Maverik Menaul and University  
Insight Construction  
General Permit SWPPP Inspection

1915 MENAUL BLVD NE  
ALBUQUERQUE, NM 87107

Inspection Date and Time

Nov 6, 2020, 2:31:21 PM

ENGINEER'S SEAL	MAVERIK UNIVERSITY AND MENAUL	DRAWN BY VP
		SWPPP LAYOUT AND ESC PLAN 1	DATE 1/6/2020
		TERRA WEST, LLC 5571 MIDWAY PARK PLACE NE ALBUQUERQUE, NM 87109 (505) 858-3100 www.tierrawestllc.com	2018062-SWPPP
			SHEET # SW1 JOB # 2018062

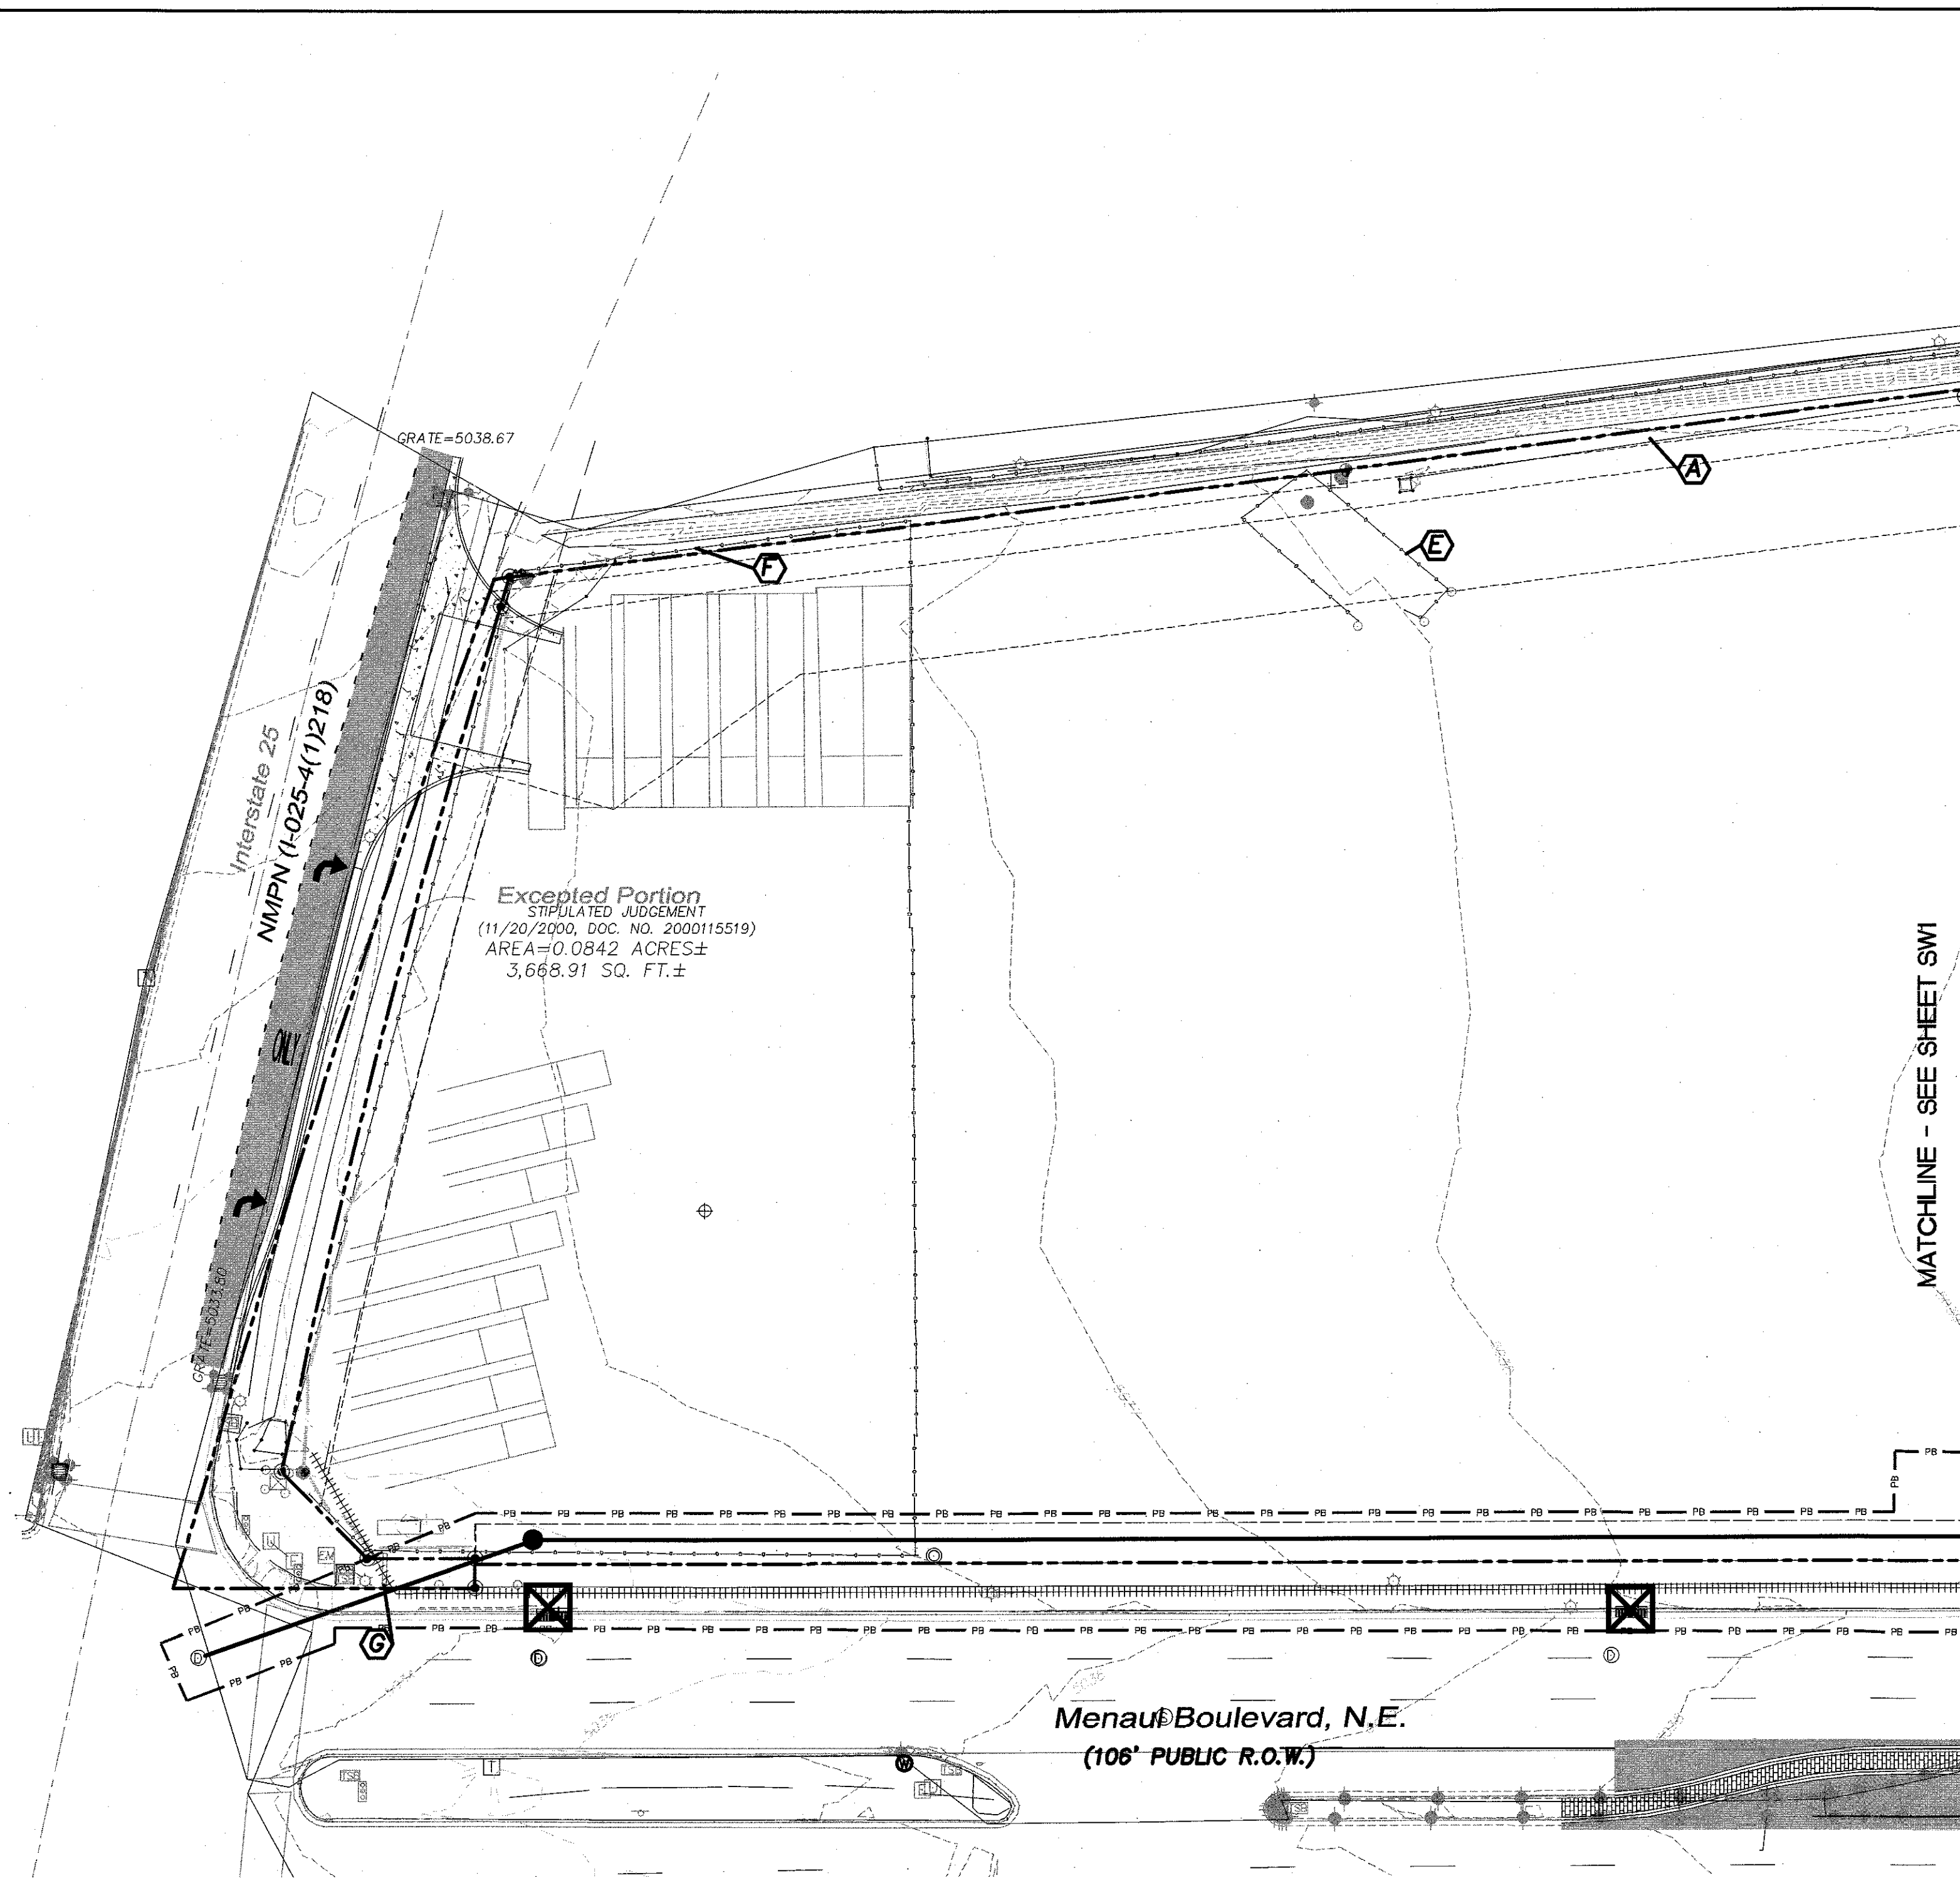
The silt fencing at the south and NW corner needs to be replaced. 3 Drop Inlets on Menaul Blvd. Needs inlet protection

Inlet protection

Title	Inspector	Date	Priority	Location	Description	Status	Closer	Notes	Imgs
Silt fence and inlet protection	Marcos Valadez	November 6, 2020	7 Days	Maverik (Menaul and University)	Repair or re-place the silt fencing on the south side of the site and provide inlet protection on Menaul Blvd. Exit/Entrance	Closed November 6, 2020	Marcos Valadez	✓ Closed November 6, 2020

I spoke with Robert (site superintendent) and he said that by 11/11/20 The silt fence and Inlet protection will be fixed.
